Mr Brad Campbell
Bursar
THE TRUSTEES OF THE SYDNEY GRAMMAR SCHOOL
SYDNEY GRAMMAR SCHOOL
10-12 COLLEGE STREET
DARLINGHURST 2010
19/05/2021

Weigall Sports Complex, Sydney Grammar School (SSD-10421)
Request for additional information

A2101

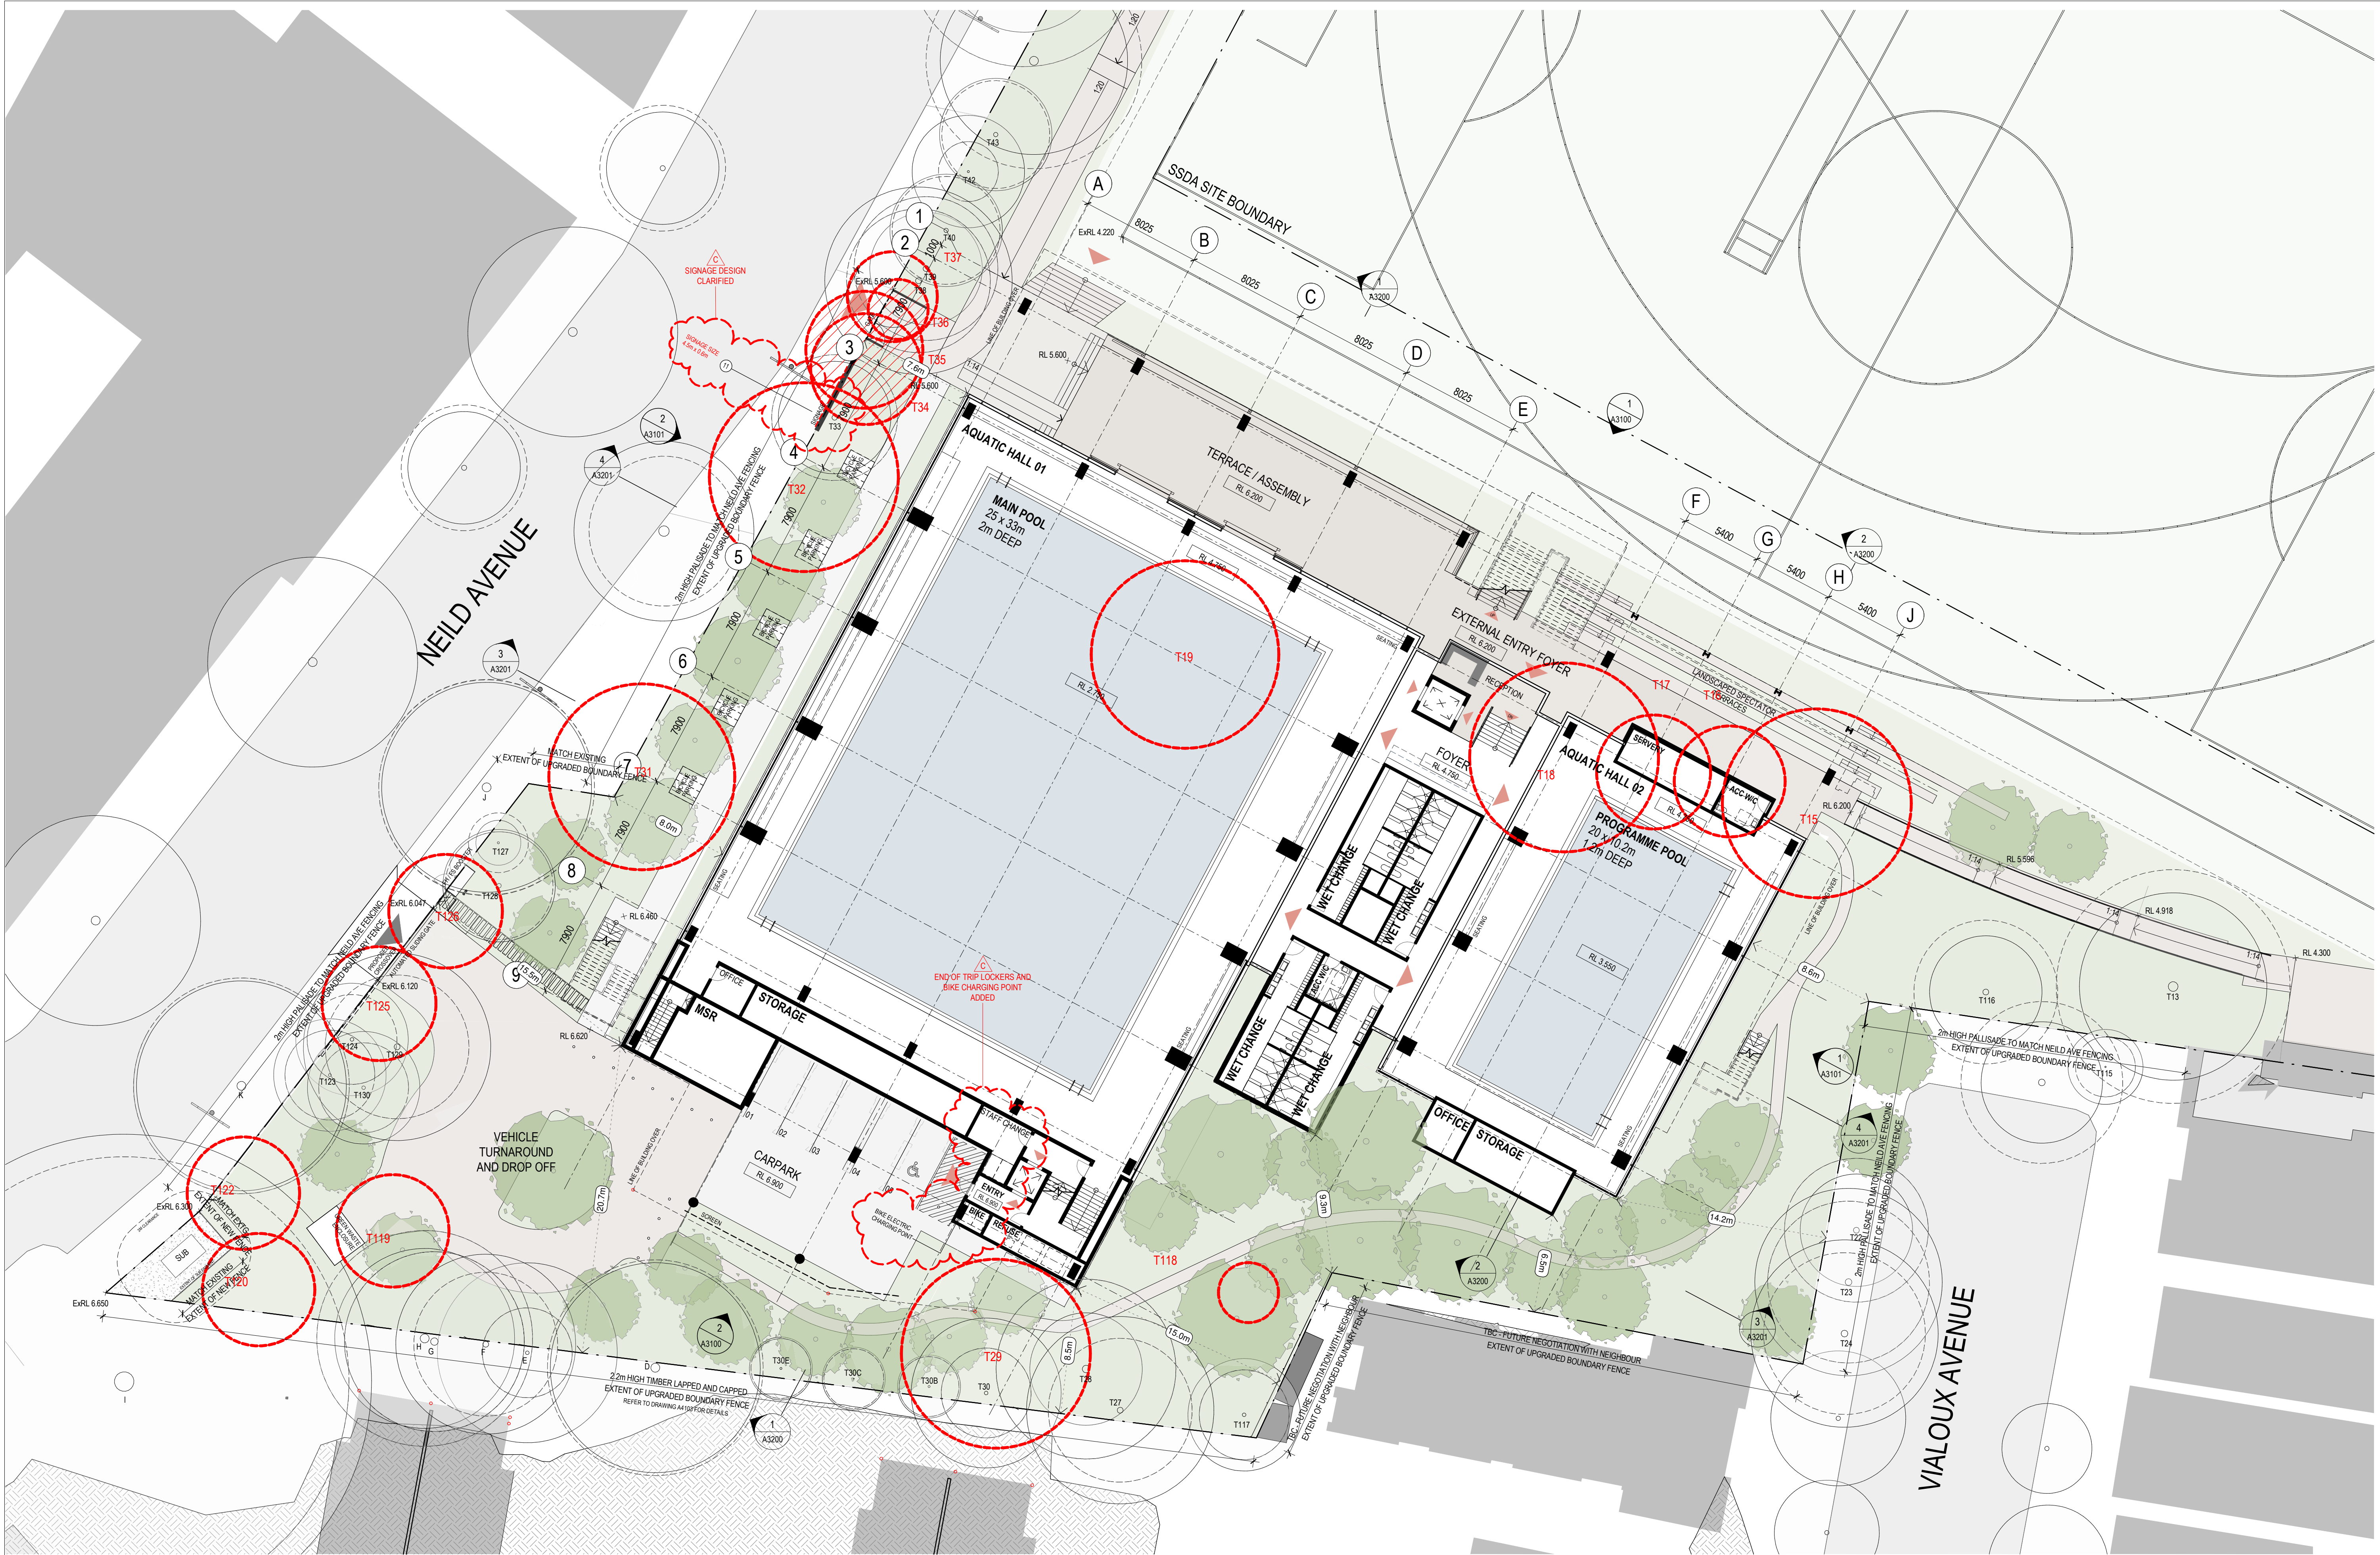
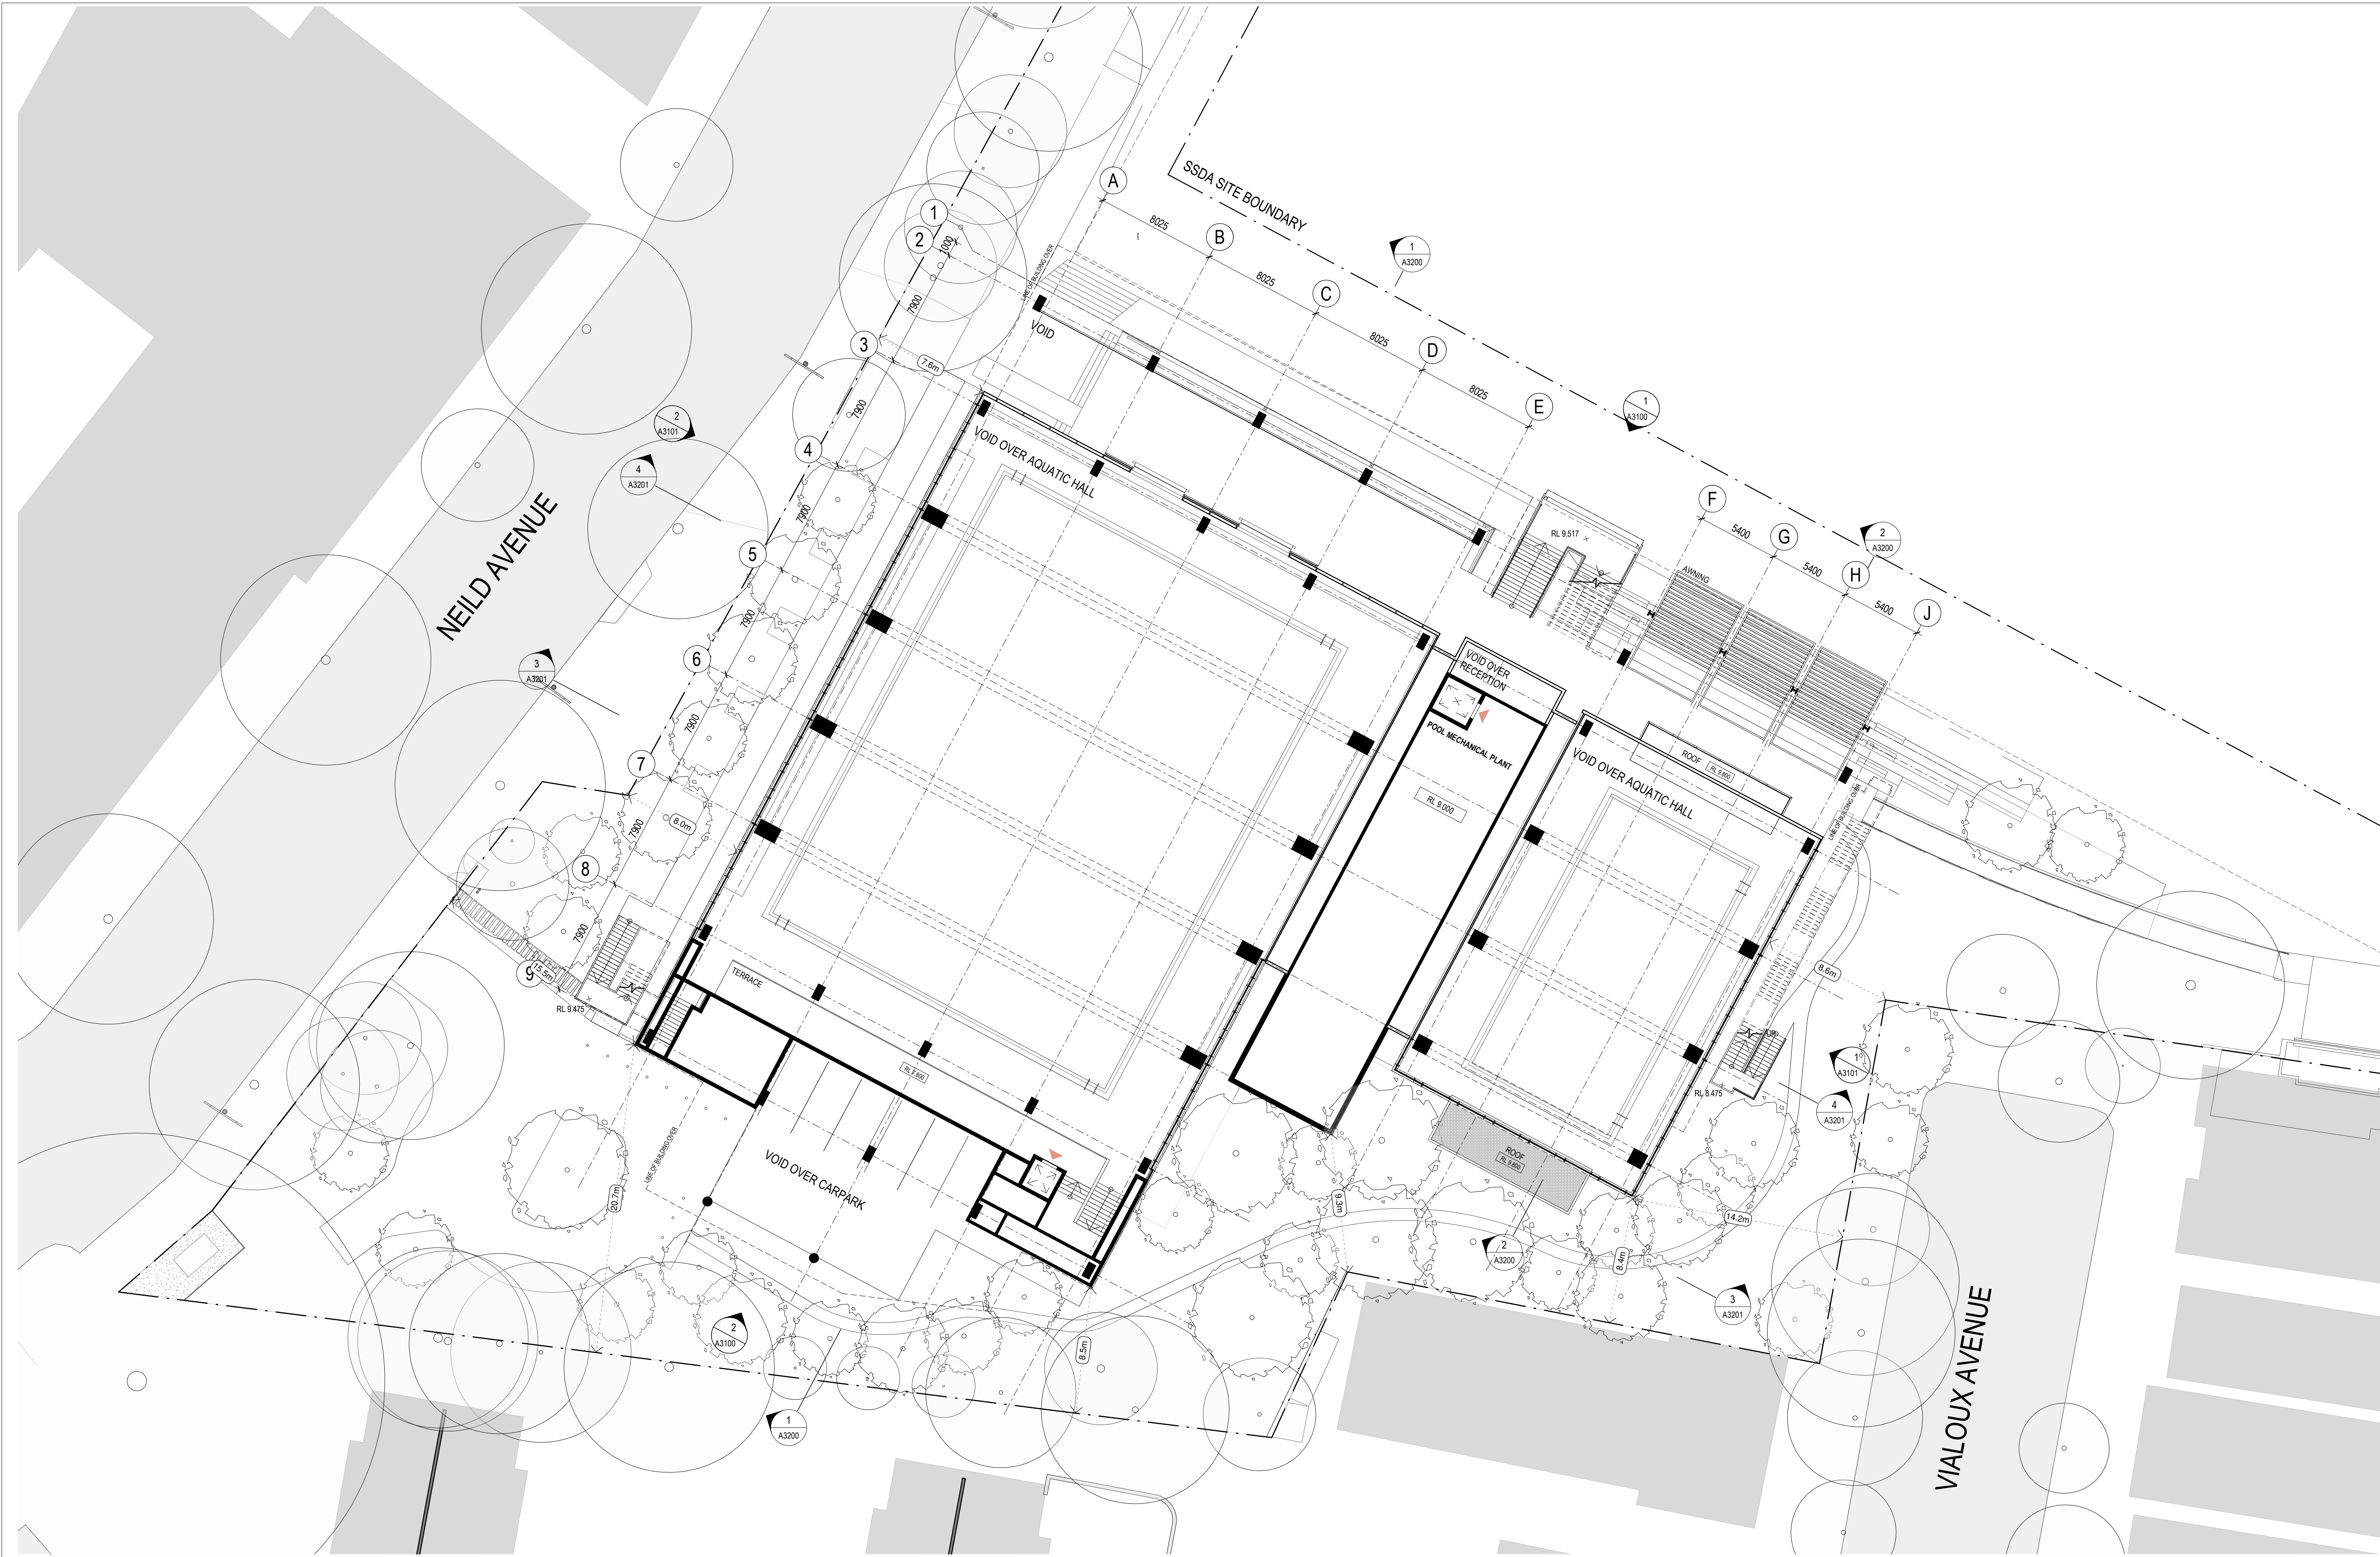
- a) The submitted drawing A4103 shows the acoustic fence as 1.83m tall (not 2.2m tall as confirmed in the EIS and drawing A2101). Confirm the acoustic fence height and update all the relevant plans. In addition, provide a date on drawing A4103.
- b) The submitted drawing A3100 should be updated to clearly indicate which windows are to comprise obscure glazing.
